Local Policing Support Team

Our Ref: LM/ARU/22/13A

RE: Land to the south of Ford Lane and east of North End Road Yapton BN18 0DS

Please find consultee comments as requested.

Drawing Title
Sections through public right of way footpath 358 and 359

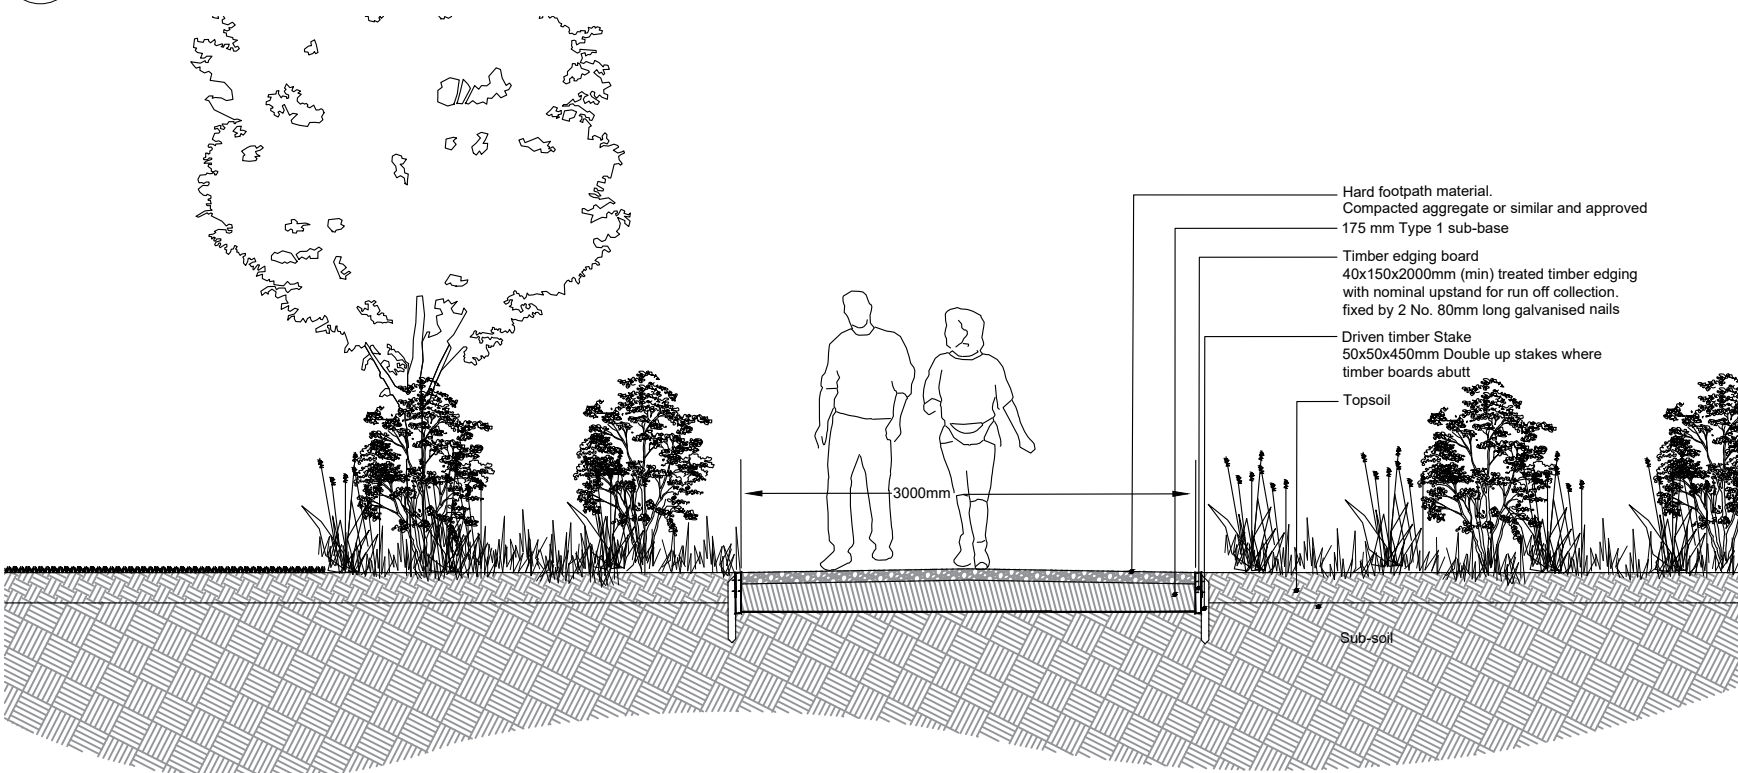
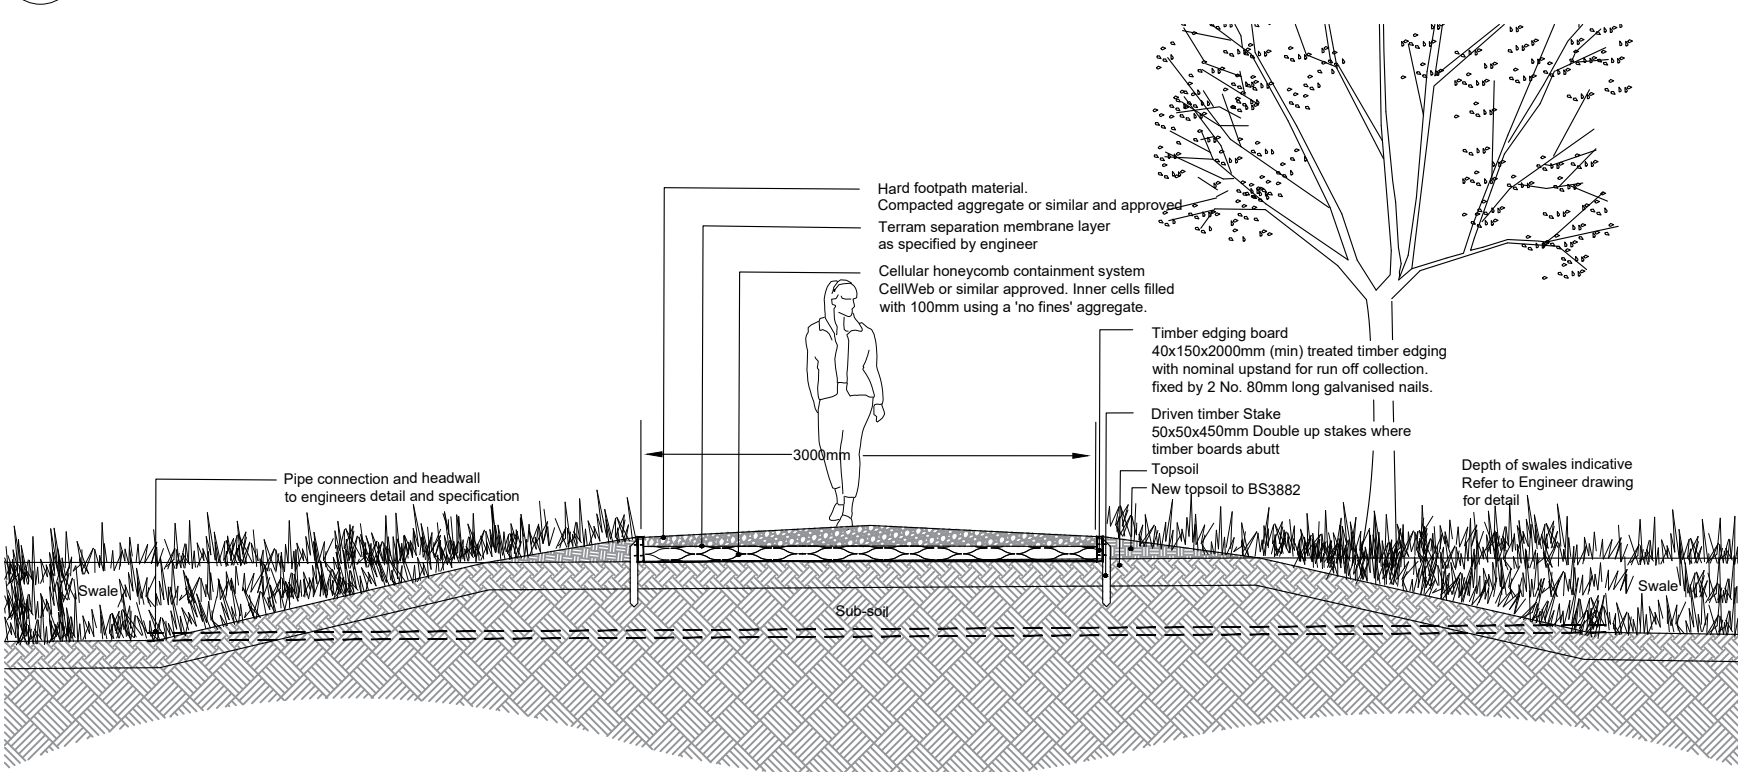
With regards to footpath design throughout this part of the development I refer the applicant to the SBD Homes 2019 Version 2 document chapter 8.

Play Area (LAP 2) - Scale 1:100@A1

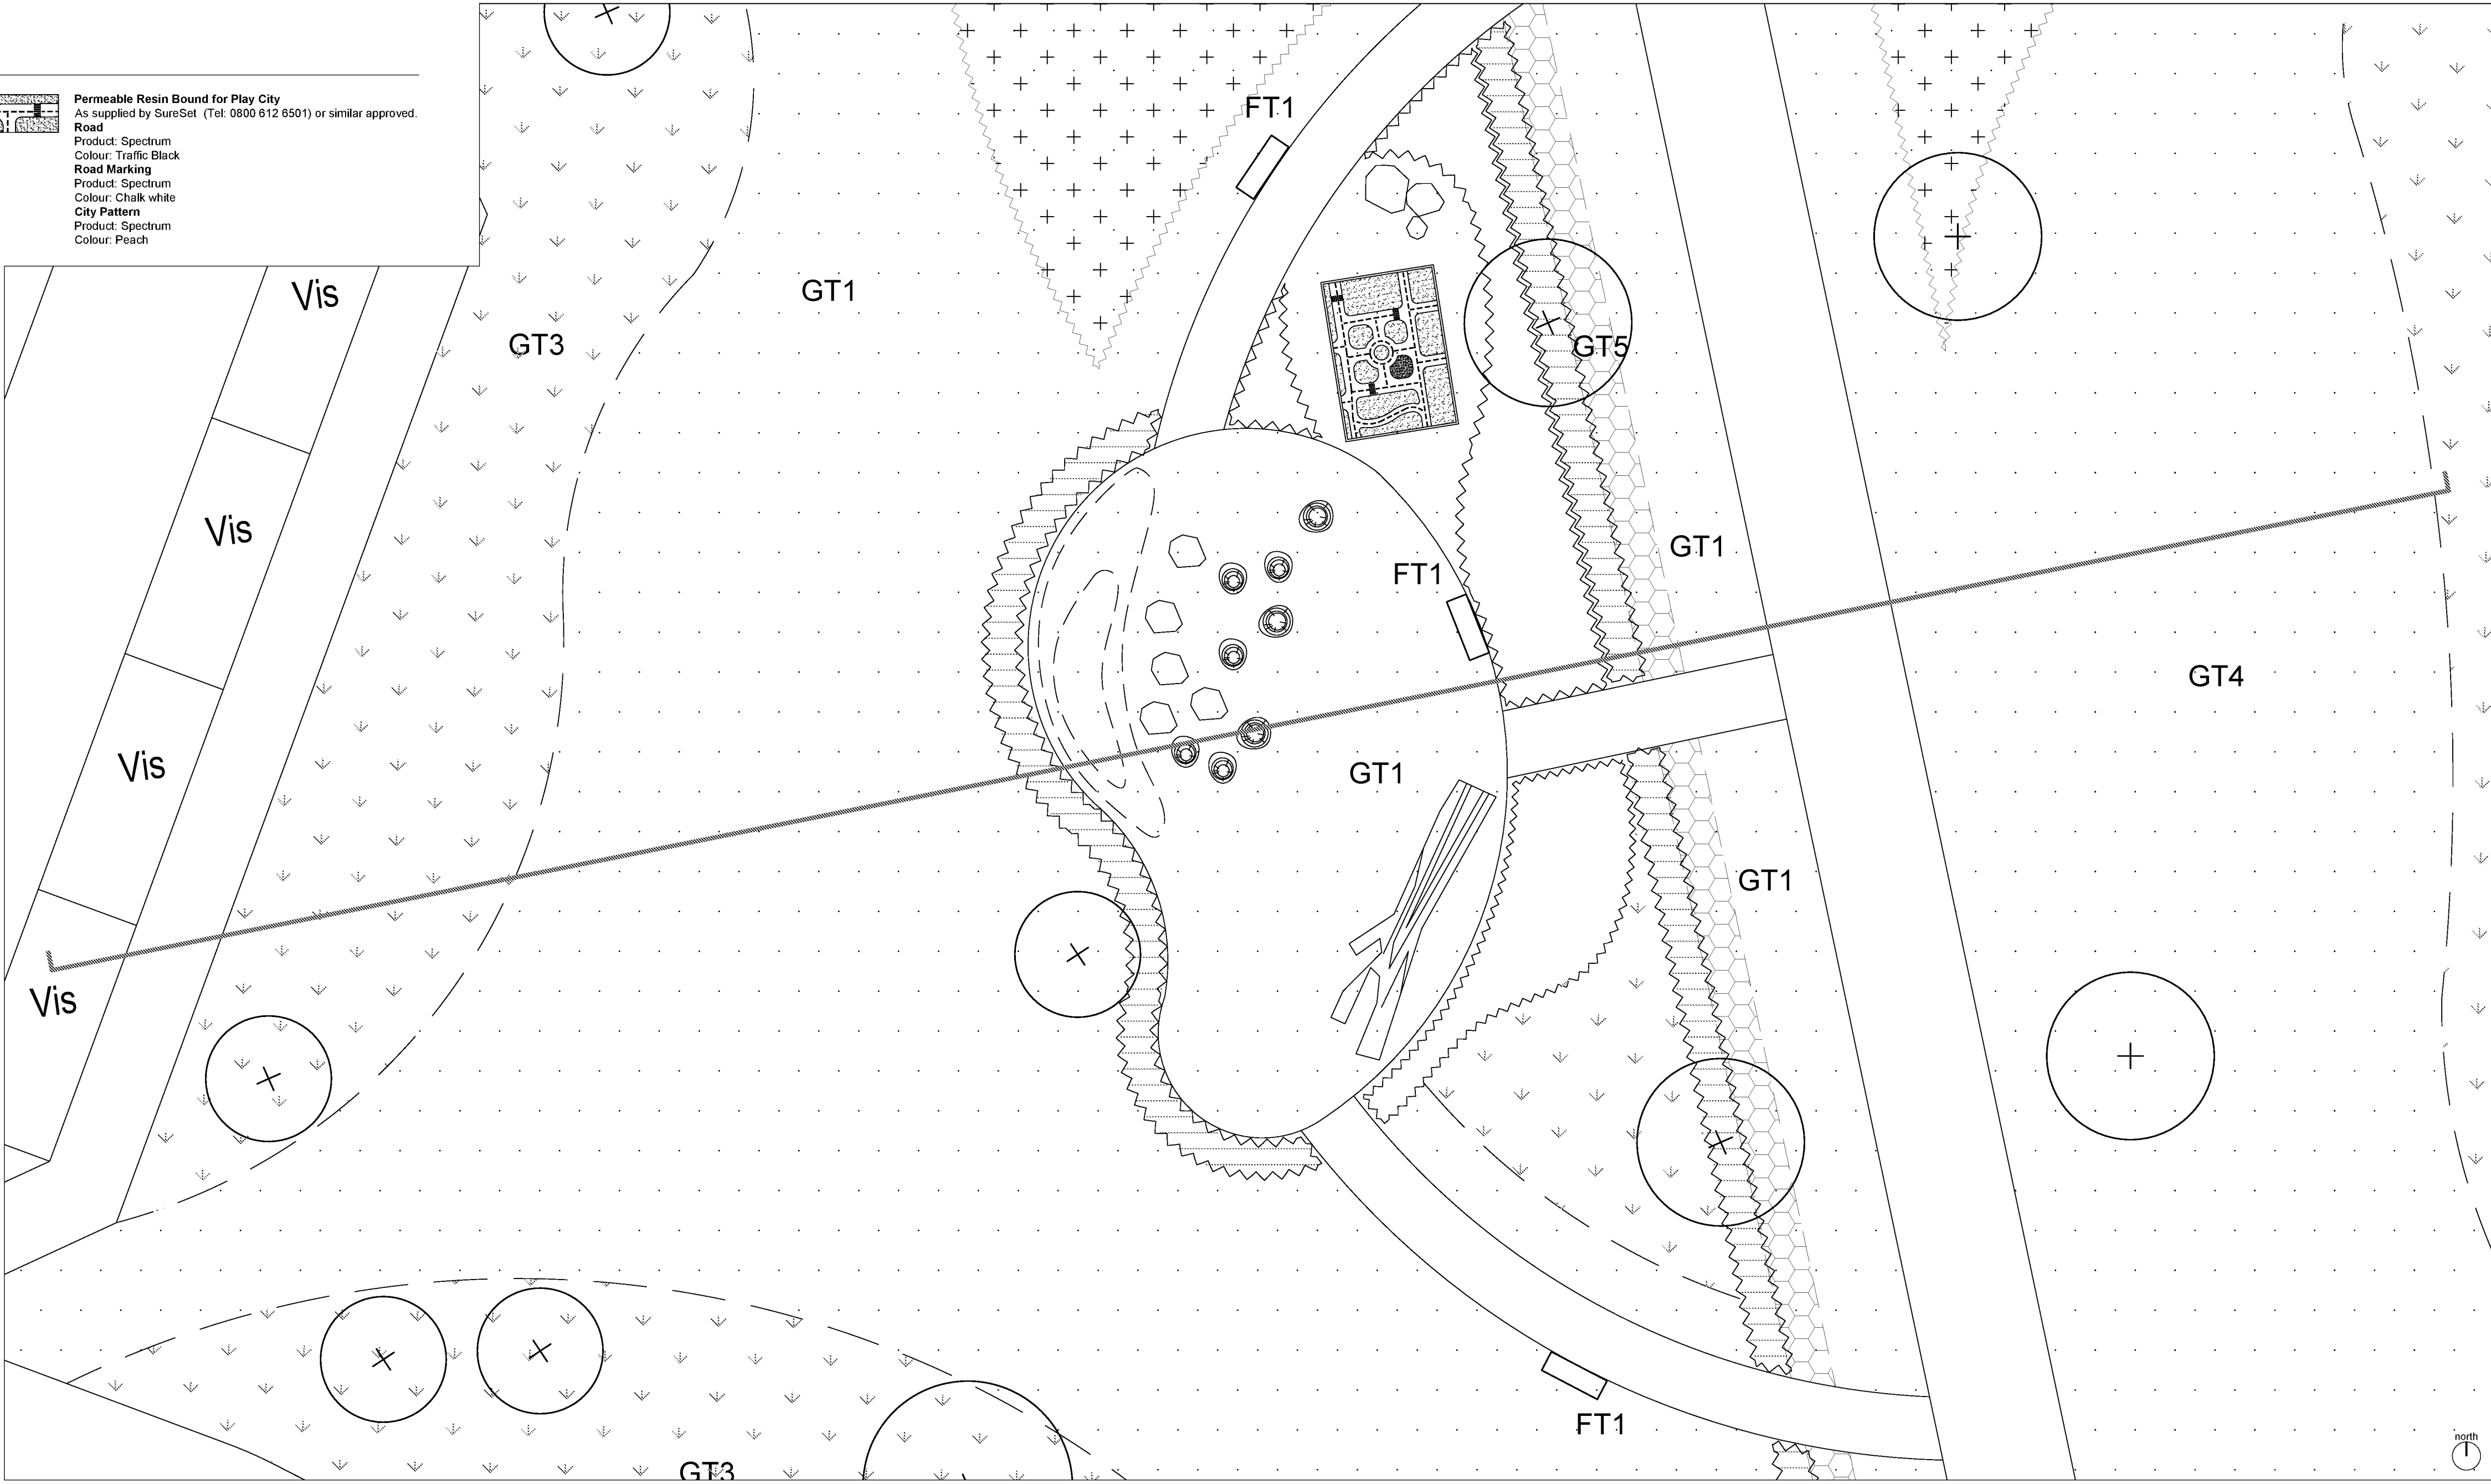
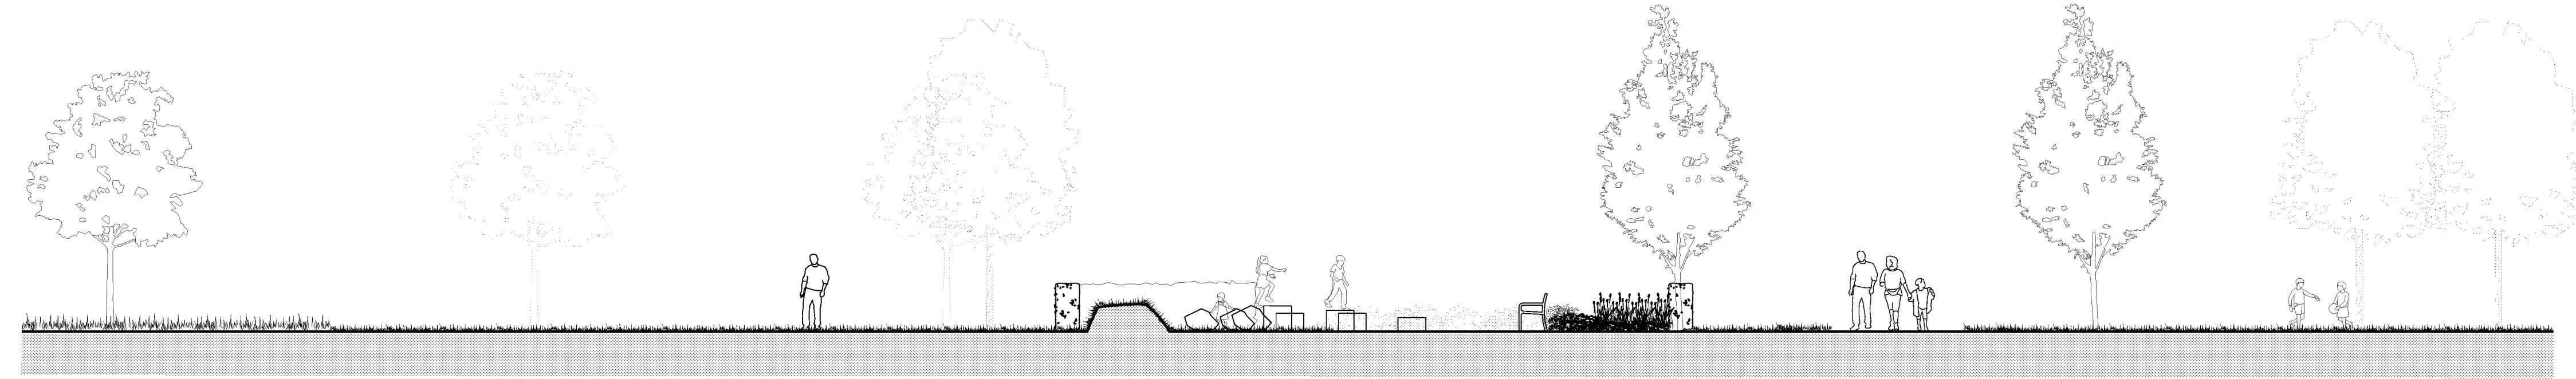
In relation to the proposed play areas - areas of play should be situated in an environment that is stimulating and safe for all children, be overlooked with good natural surveillance to ensure the safety of users and the protection of equipment, which can be vulnerable to misuse. They should be designed to allow natural surveillance from nearby dwellings with safe and accessible routes for users to come and go. Boundaries between public and private space should be clearly defined and open spaces must have features which prevent unauthorised vehicular access. I would ask that the play area is surrounded with railings with self-closing gates to provide a dog free environment.
